From: [REDACTED]
To: [A1 Birtley to Coal House](#)
Subject: Environment Agency Response to A1 Birley Coal House Improvement Scheme
Date: 22 February 2020 12:37:00
Attachments: [REDACTED]

**PLANNING ACT 2008 – SECTION 88 AND THE INFRASTRUCTURE
PLANNING (EXAMINATION PROCEDURE) RULES 2010 – RULE 6.
APPLICATION BY HIGHWAYS ENGLAND FOR AN ORDER GRANTING
DEVELOPMENT CONSENT FOR THE A1 BIRTLEY TO COAL HOUSE
IMPROVEMENT SCHEME (DEADLINE 2: THE EXAMINING AUTHORITY'S
WRITTEN QUESTIONS) NZ2590258148
A1 BIRTLEY TO COAL HOUSE**

**A1 Birtley to Coal House Improvement Scheme DCO Application Planning
On behalf of the Environment Agency (Deadline 2: 25 February 2020)**

Figure 4: Sketch of the proposed temporary works

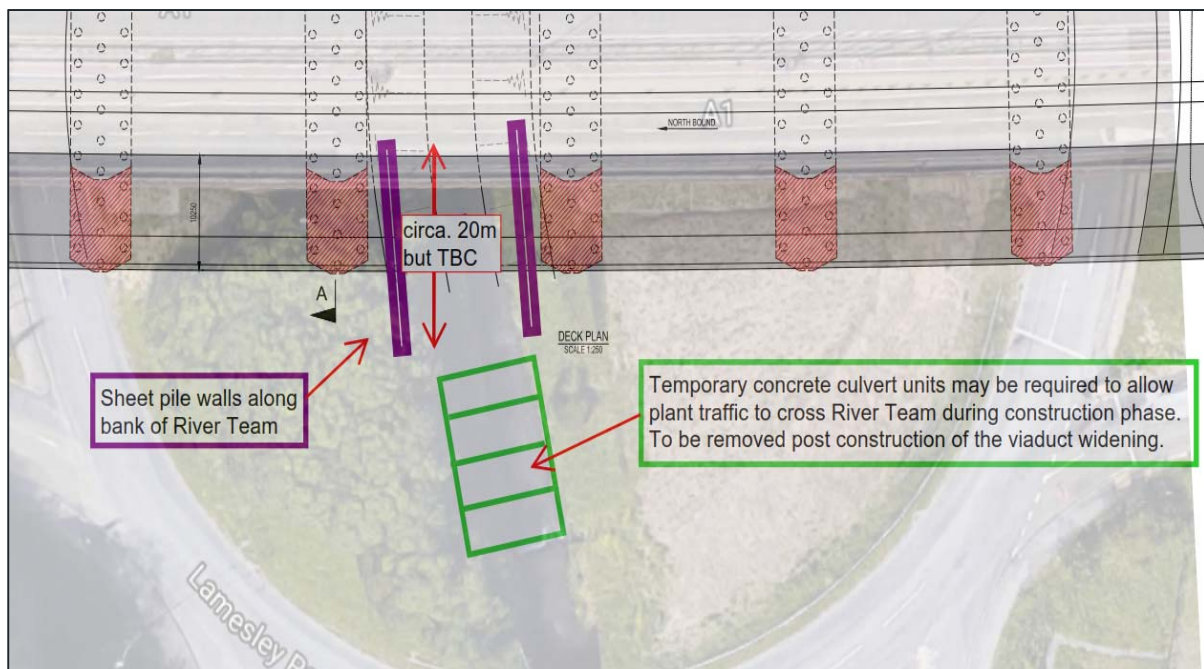
The River Team at the Coalhouse Roundabout will be subject to a temporary culvert during works. No detail is provided in the CEMP or the EIA on the removal of the culvert and restoration of the river once the works are complete, and no habitat mitigation is shown on the Environmental Masterplan at the river in this location.

Reinstating the river post-construction needs to ensure that a natural watercourse is designed into the scheme and includes measures to improve on the existing

relatively poor quality habitat available for fish and other species within this straightened and uniform section of the River Team. The CEMP will need to include the process and design considerations as per other landscape and mitigation requirements elsewhere in the document for the restoration of the river once works are complete.

Figure 3-2 – Channel Design Concept - Plan

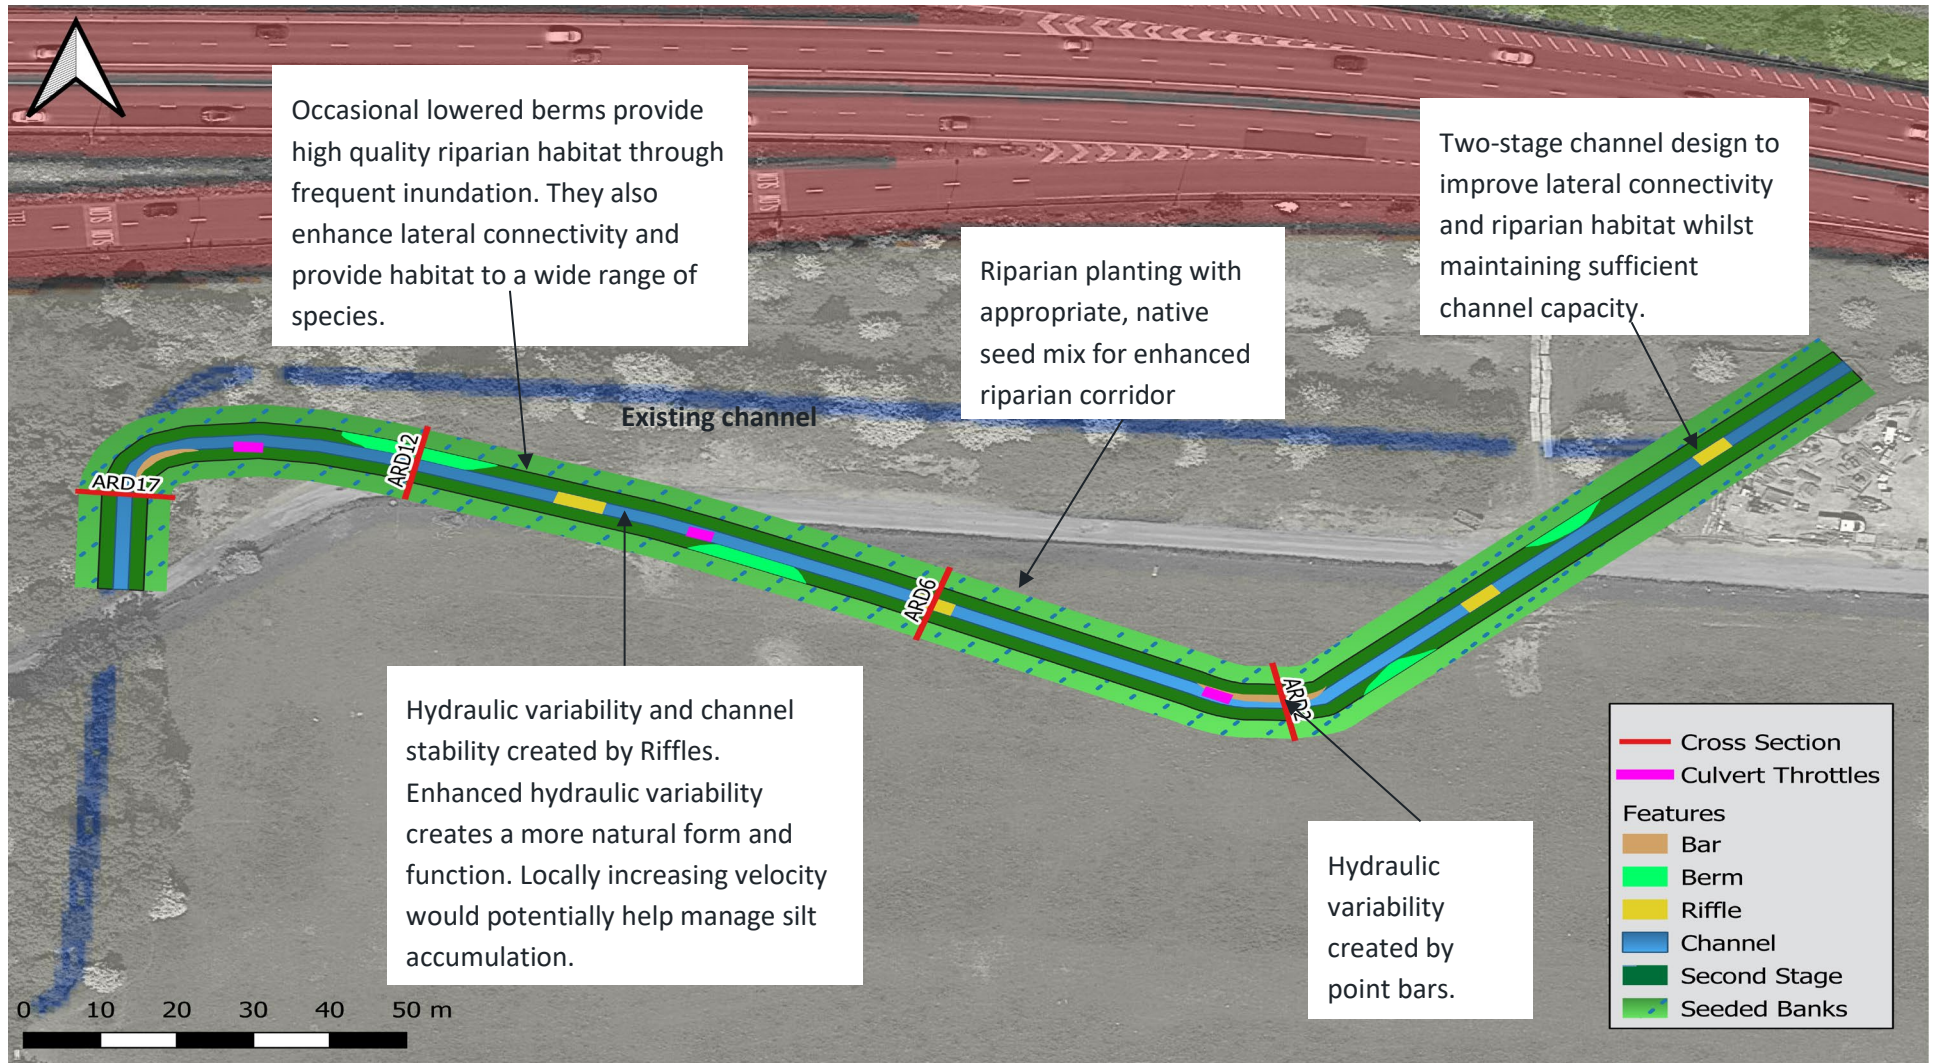
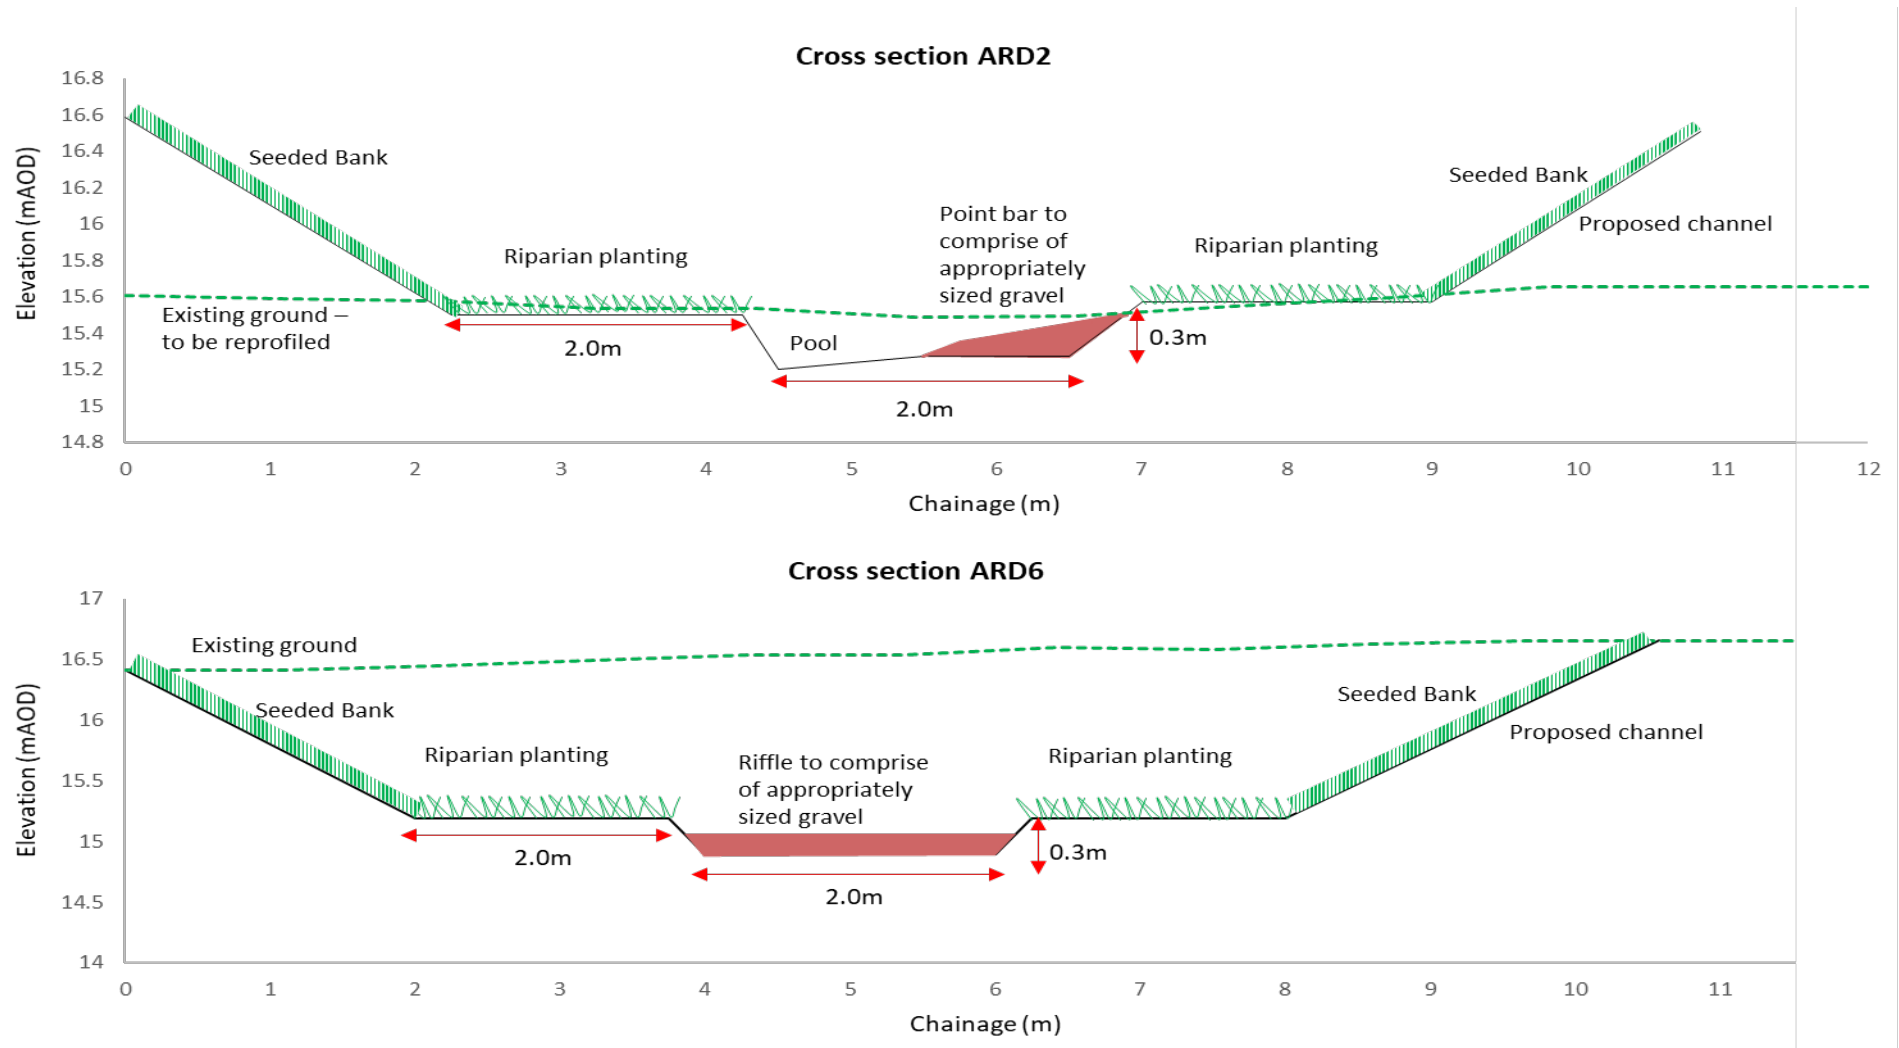
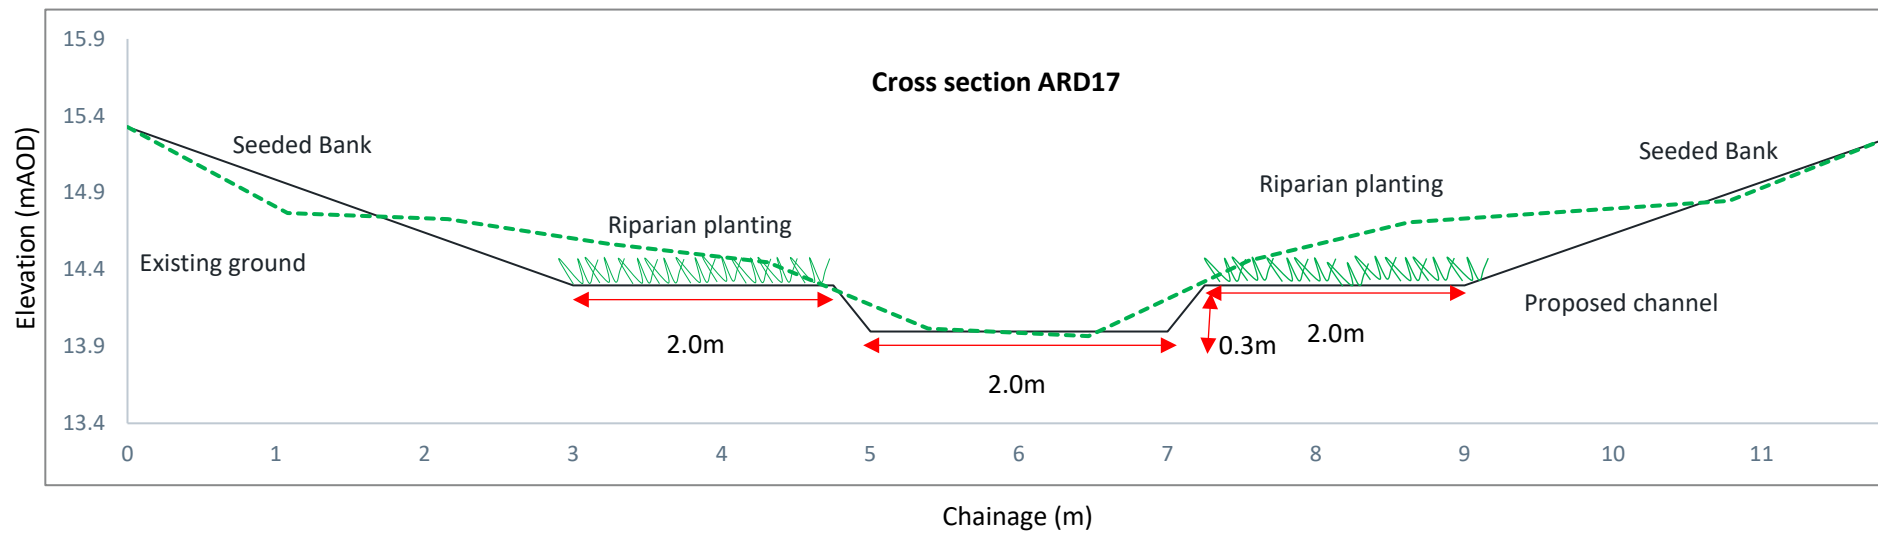
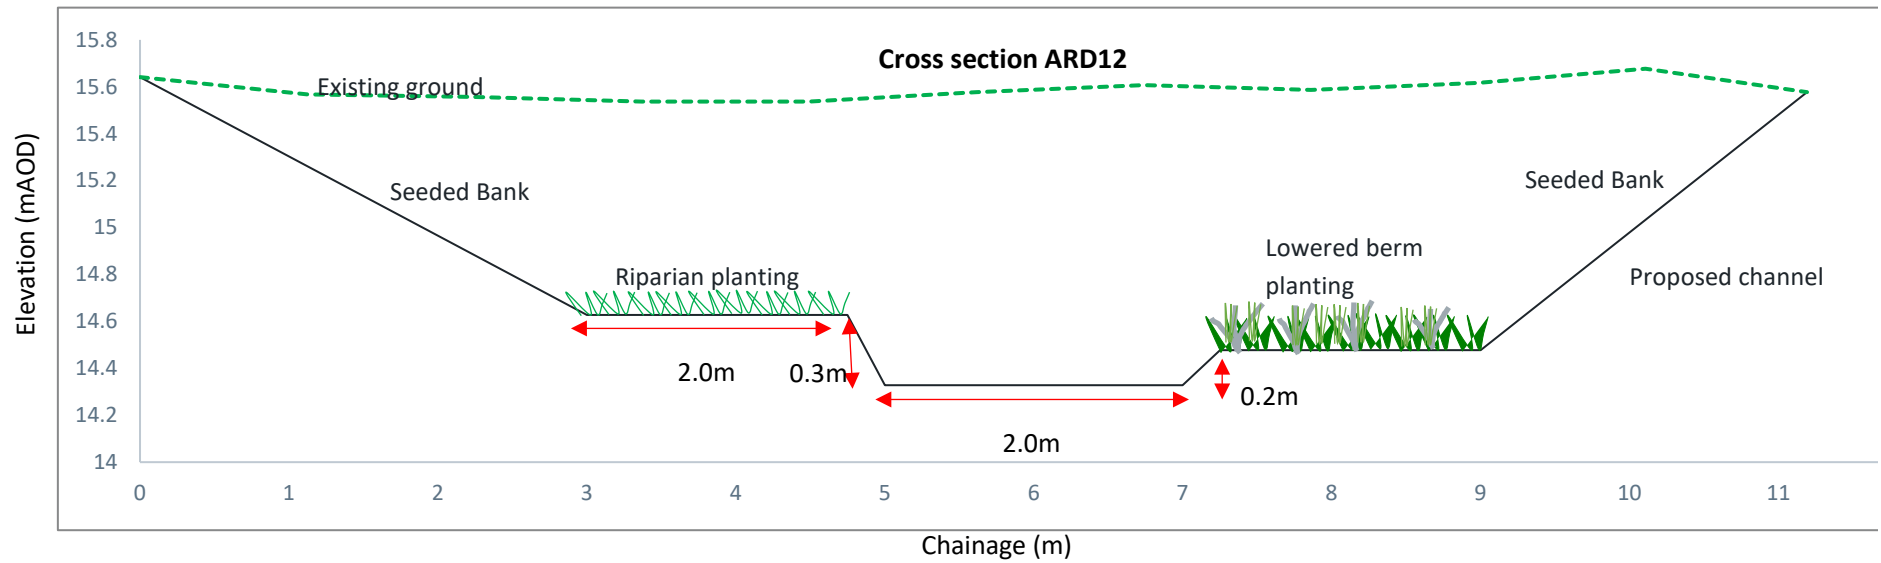
<p>scheme.</p>
W10	<p>It is positive to see that there is opportunity for river restoration included within the CEMP for options in relation to the Allerdene Burn.</p> <p>Any design at this location should have input from a suitably qualified geomorphologist in order to ensure a suitable design is brought forward that maximises the morphology of the channel and riparian zone for habitats and wildlife.</p> <p>The following should also be considered:</p> <p>There are two options for the reinstatement for the Allerdene Burn, an updated culvert with greater capacity (embankment option) or an open channel (viaduct option). Both options at detailed design stage will need to be designed in such a way as to maximise environmental benefits:</p> <ul style="list-style-type: none"> • For the Allerdene embankment option, there would be a re-engineered culvert. There are in-channel improvements which can be made to increase the flow diversity of the modified channel, which can in turn affect the morphology of the channel and therefore the biodiversity of the channel. This needs to be considered in any detailed design. • For the Allerdene viaduct option, the Allerdene Burn is noted to be realigned as part of the scheme. There is an opportunity to realign this in such a manner as to work with natural processes in order to gain a more diverse fluvial system than a uniform straight section of channel. This needs to be considered in any detailed design as opposed to an open ditch. • For both the viaduct and embankment options, it is noted that flow control measures will transfer water from the channel out onto the floodplain during a 1% event. The design of the channel and the adjacent floodplain could allow more frequent flooding, with the potential to trap and store fines and nutrients, help reduce downstream flooding and benefit local biodiversity. We would welcome proposals as to how this may be achieved.
